Planning Comments V1 -

**GEOLOGIC HAZARDS EVALUATION AND
PRELIMINARY GEOTECHNICAL INVESTIGATION
THE COVE AT WOODMOOR
DEER CREEK WAY AND BURNING OAK WAY
WOODMOOR, COLORADO**

PUDSP-22-008

**Location of
Exploratory
Borings**

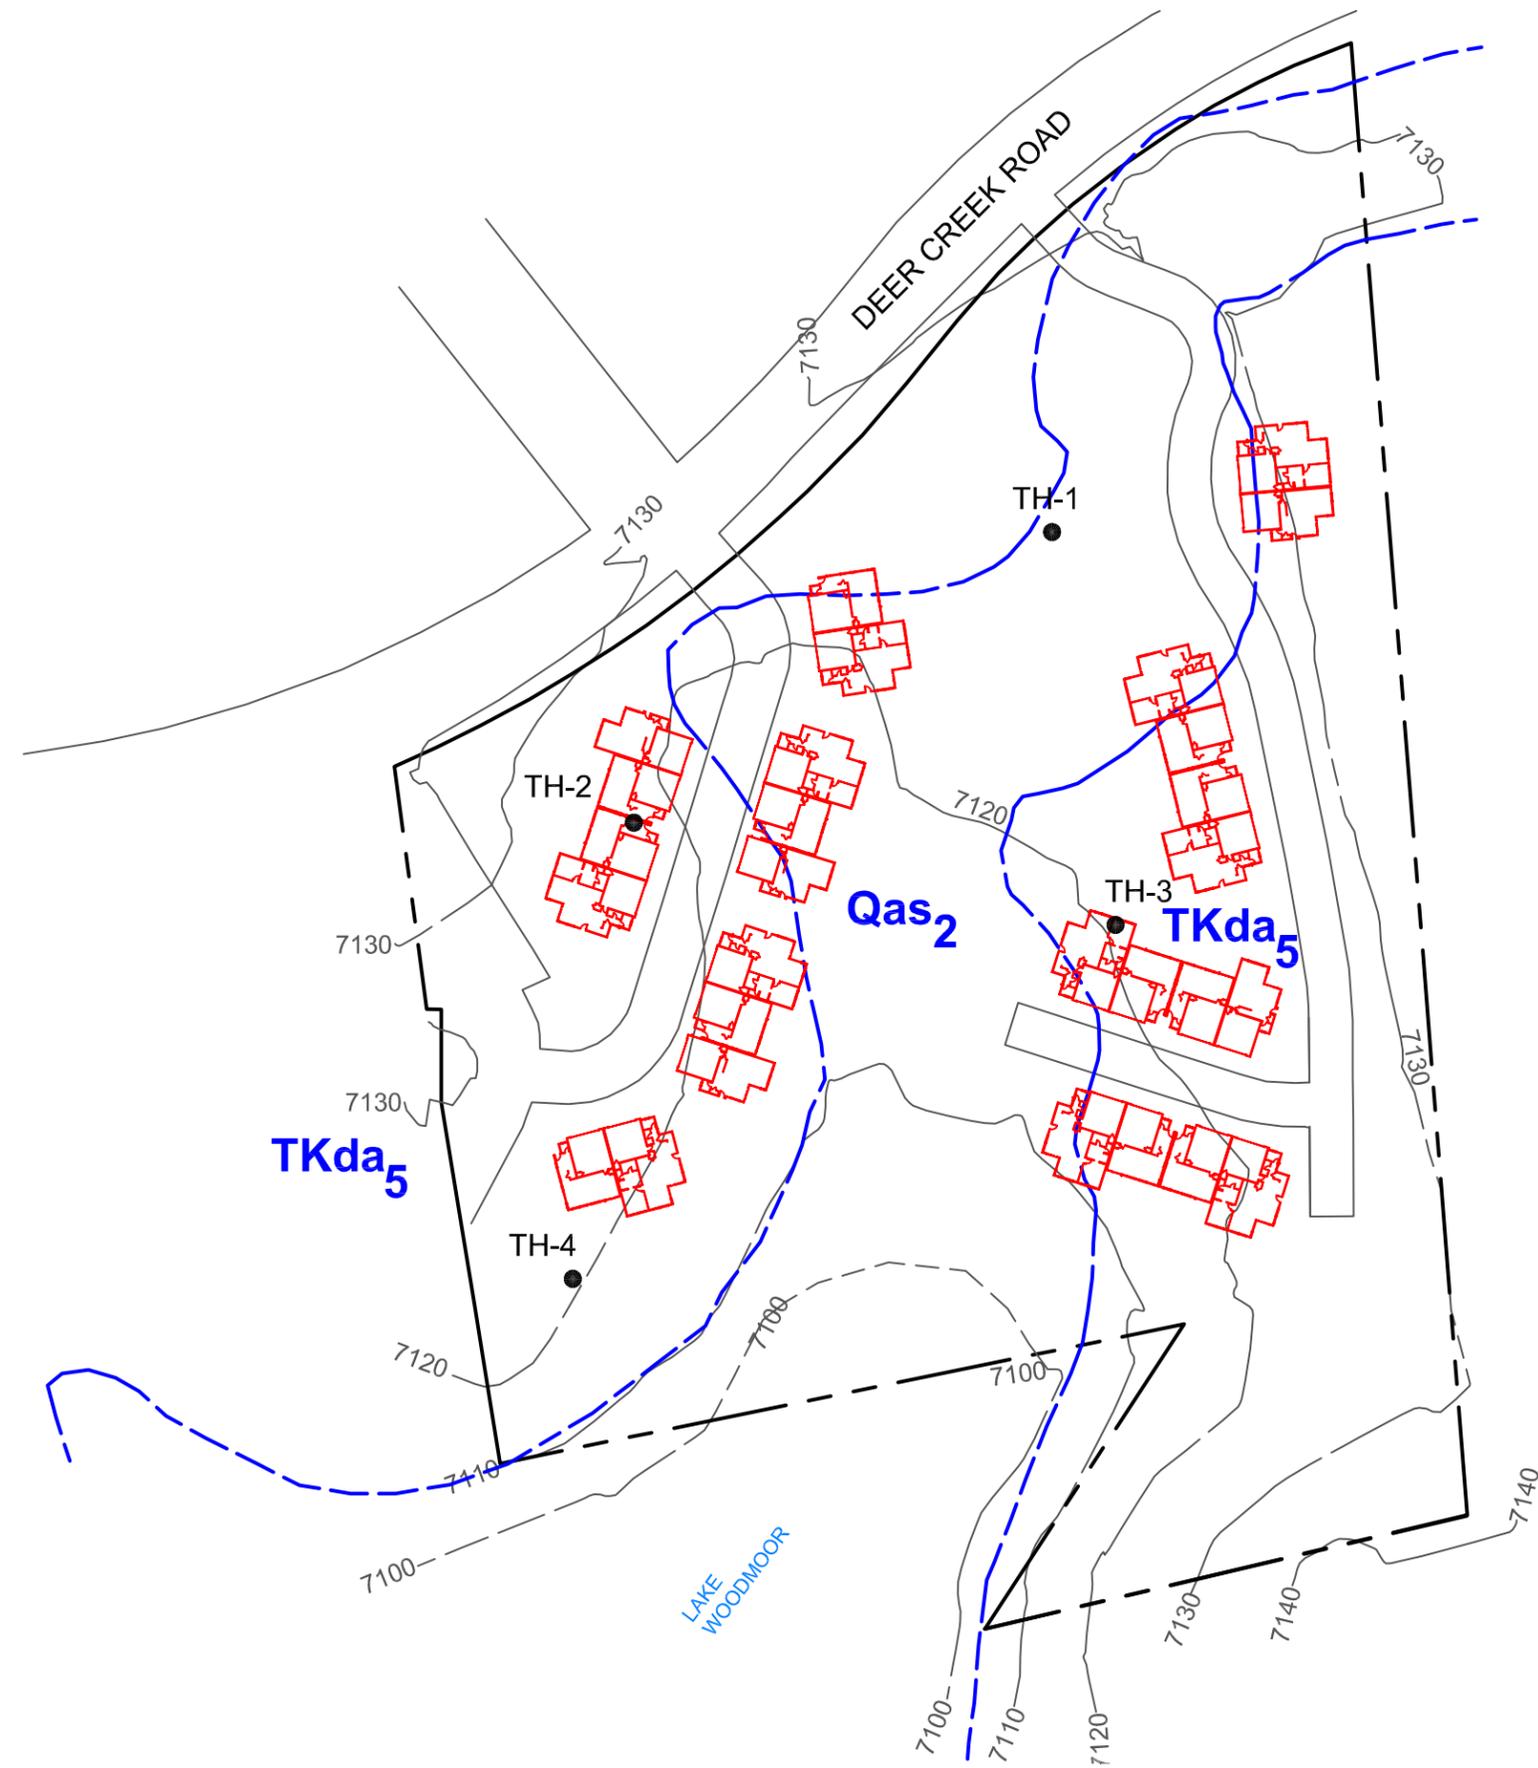
The geologic hazards evaluation was drafted with the original design concept. That concept has changed and many more buildings are proposed in different areas of the site. This report should reflect those changes, especially the underground channeling of the 100 year floodplain and the proposed buildings on the current flood plain.

Also, What would be the impacts of channelizing the 100 year flood plain on the surrounding soils? Would the channeling decrease the moisture content of the soil and therefore change the soil dynamics? Will this create a problem with soil movement in the future?
